Dear Ms Gibson,
RE: 1 Lawson Square Redfern 2016

We refer to your email of 10 February 2016 wherein you request further consideration and a response to the review by the Department of Planning and Environment to the Section 96 drawings (Issue C) lodged with the department on the 7 December 2015. You have requested that we provide a response to comments raised by both Russell Hand at the City of Sydney and additional matters raised by the Department of Planning and Environment.

TOWER 1

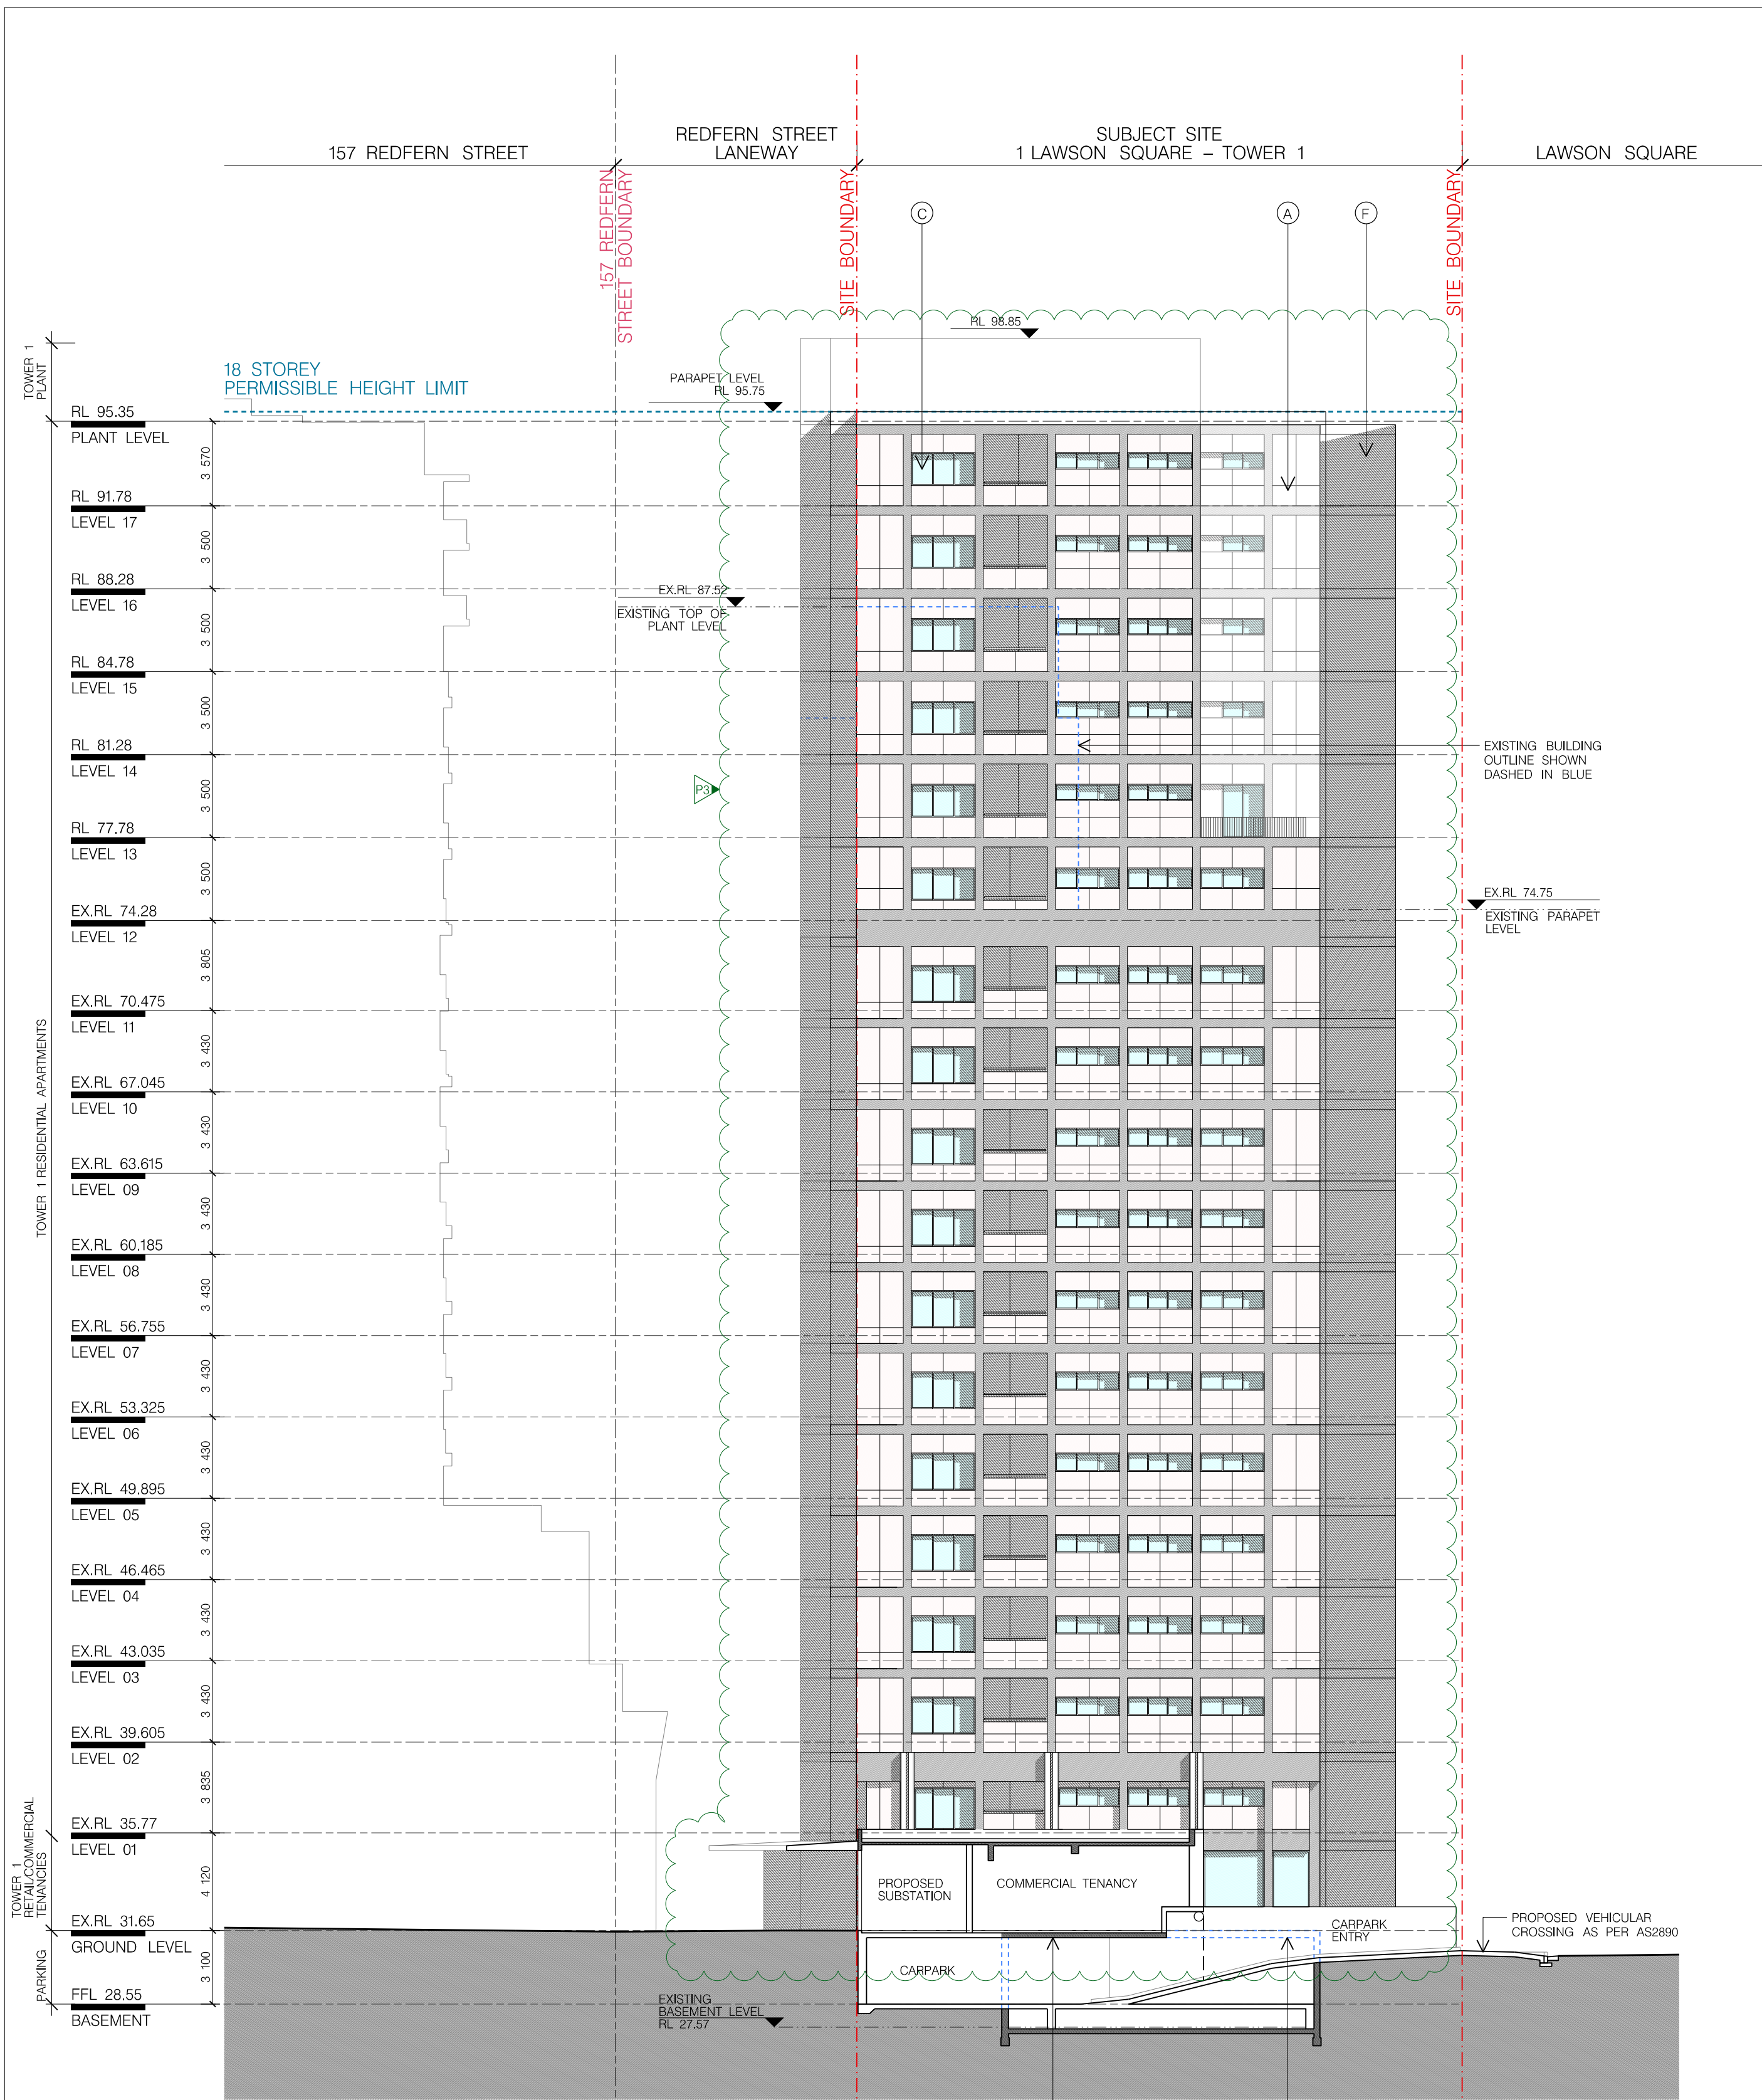
- 2. Northern balconies on both towers should remain an overhang of the building as opposed to the columns hitting the ground. The drawings call these columns "blade walls" despite their heavy appearance. The shape of the columns creates CPTED issues in that hollow recesses, alcoves and corners allow concealment opportunities and blocking of street surveillance. Lightweight blade walls that commence from Level 1 and above are favoured. An alternate appears to be tapering the profile of the columns where they hit the ground so that alcoves and concealment opportunities are minimised.*

4. *Justification for including pedestrian ramps within the future public domain is necessary. Although the ramps are within the site boundaries, building entries should be at grade and any level differences handled within the building. The new ramps at south-western corner of Tower 1 are particularly unresolved. There appears to be a high wall around the eastern retail ramp (as is evident in the photomontages) and an enclosed alcove around the southern residential ramp (evident in the elevations). Both of these create Crime Prevention Through Environmental Design (CPTED) issues in relation to concealment and should be deleted or reimagined in the scheme.*

5. *Reinstatement of a café or food premises tenancy along Redfern Lane between the buildings is desirable for activity and life along the laneway. In exchange for the proposed placement of substations along the lane, the proposal needs to compensate for poor activation. The longevity of the NSW Police using the reformatted commercial tenancy in Tower 2 is not guaranteed, along with the surveillance of the laneway this may create, both physical and perceived.*

Response: The ground floor/ public domain plan has been reconsidered to adopt the comments raised by the City of Sydney. The current 'hollow recesses/ alcoves' have been removed in lieu of glazing that extends to the perimeter of the building form. Please refer to drawing SK-04 for further detail.

Response: The pedestrian ramps within the public domain have been reconsidered throughout the proposal. The eastern and western pedestrian ramp have been removed in lieu of 'on grade' entry to the potential café on the south western corner and the lobby entry on the eastern façade. The northern entry ramp has been reconsidered to maximise building surveillance to the ramp from the future retail/ café tenancy. Please refer to drawing SK-04 for further detail.

Response: Despite the financial advantages of having the proposed substations sitting side by side, they have now been placed in different locations to minimise poor street activation in the laneway. As suggested, the possible café entry has now been located on the southwestern corner with on-grade entry for an improved urban design outcome. Please refer to drawing SK-04 for further detail.

DRAWING No:
S96 - 1302

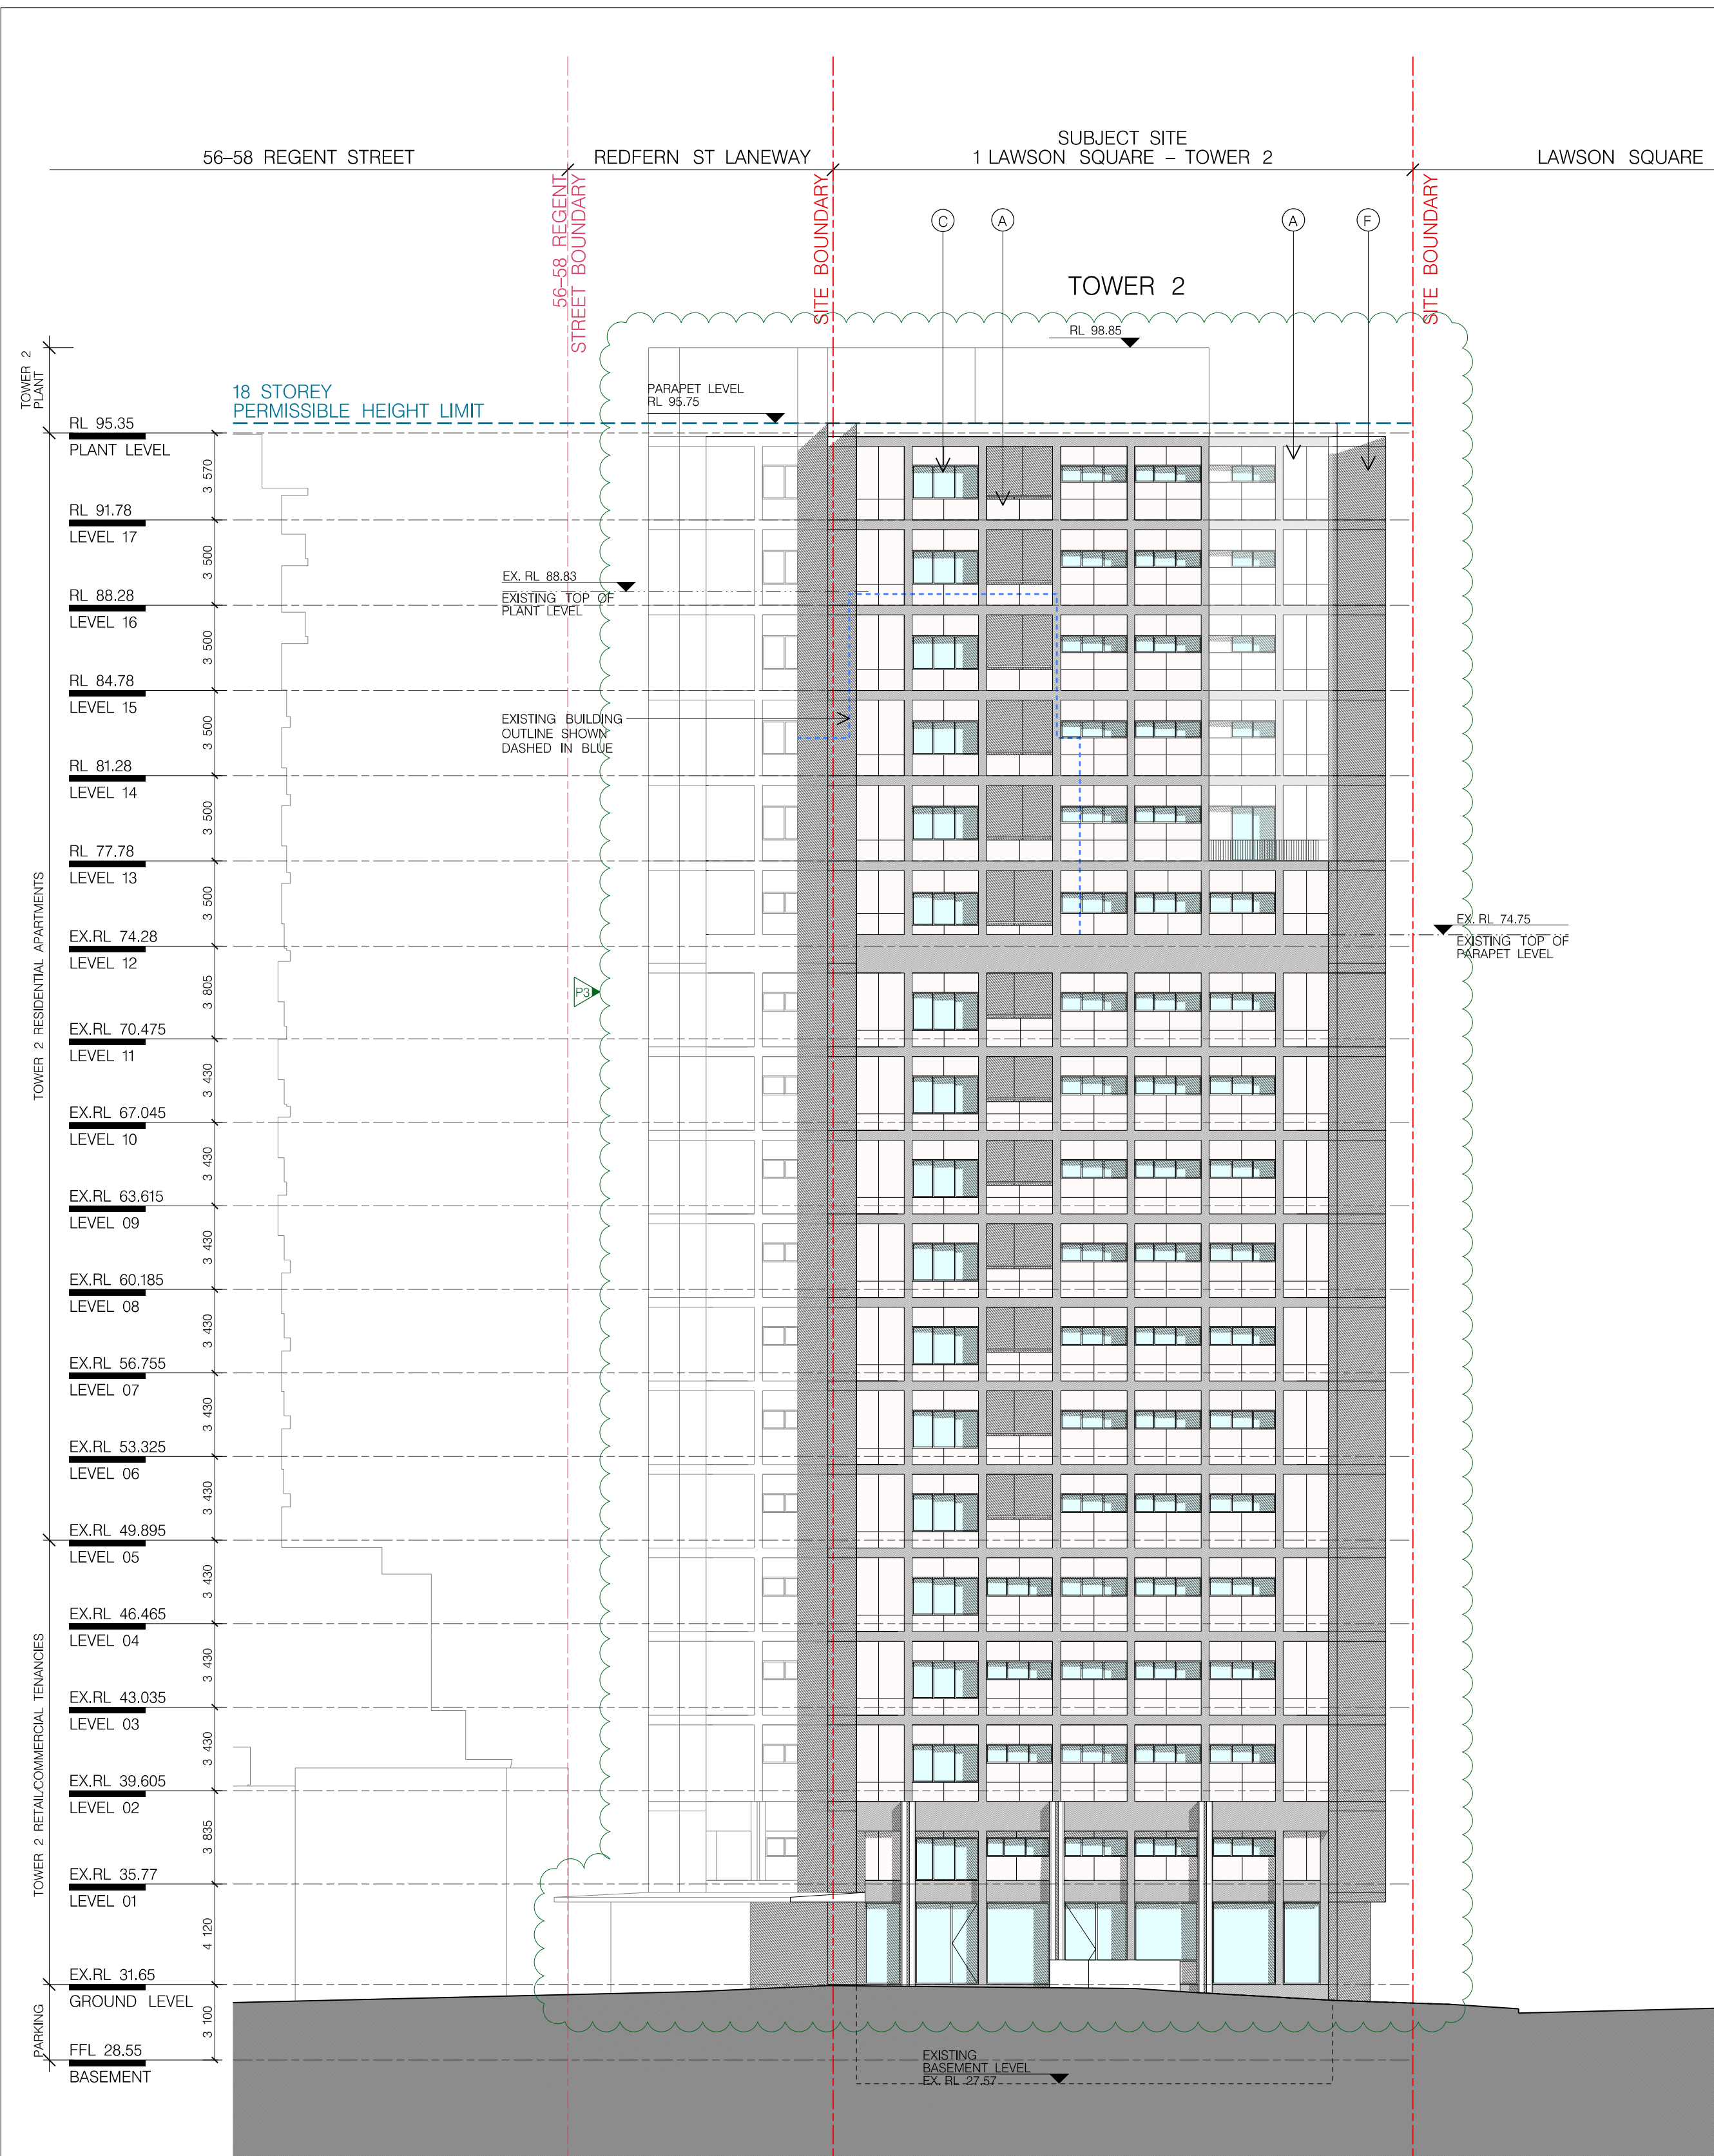
- 3. The façade materials on the southern elevations of both towers is not documented and appears to be painted concrete. The fire stair external walls are hatched dark grey but no material is noted in terms of finish or cladding. As these stairwells occupy a great deal of the laneway frontage and will be highly visible from surrounding development, the materials require resolution. With the current approval these external walls are relatively low-key given the complexity of the building geometry. Now the walls are stark and deserving high quality architectural detailing.*

5. *Clarification of the façade treatment and materials schedule is requested as the elevations differ from the photomontage, and some materials not documented.*

Response: The materials to the entire southern elevation have been reconsidered to achieve the desired high quality architectural detailing. GRC screens have been introduced to the south facing units to give the subject façade increased articulation. The stair core expression has been reconsidered with a textural sandblasted finish to the concrete. Please refer to drawing SK-05 for further detail.

Response: We have provided a façade material schedule clearly indicating the material treatment to all facades. Please refer to drawing SK-05 for further detail.
